Our Ref: R/32/20/HH
Your Ref:

Town & Country Planning Act 1990 (as amended)
Town & Country Planning (Development Management Procedure) (England) Order 2015
Application for Planning Permission for Works or Extension to a Dwelling

Development Demolition of covered walkway and erection of single storey side addition
Location 14 Sutton Avenue Rustington

Block Plan - Scale 1:500

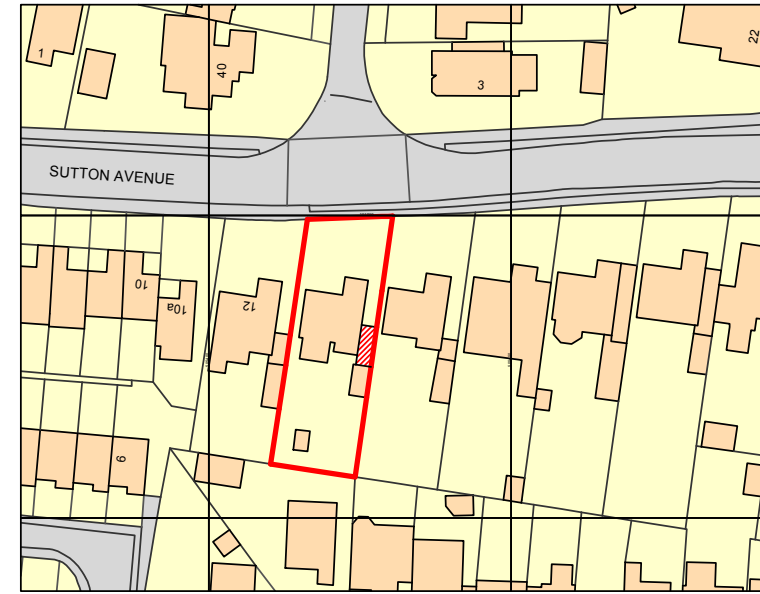
Block Plan: You are required to include dimensions on the block plan from the proposed extension to all site boundaries. Please amend.
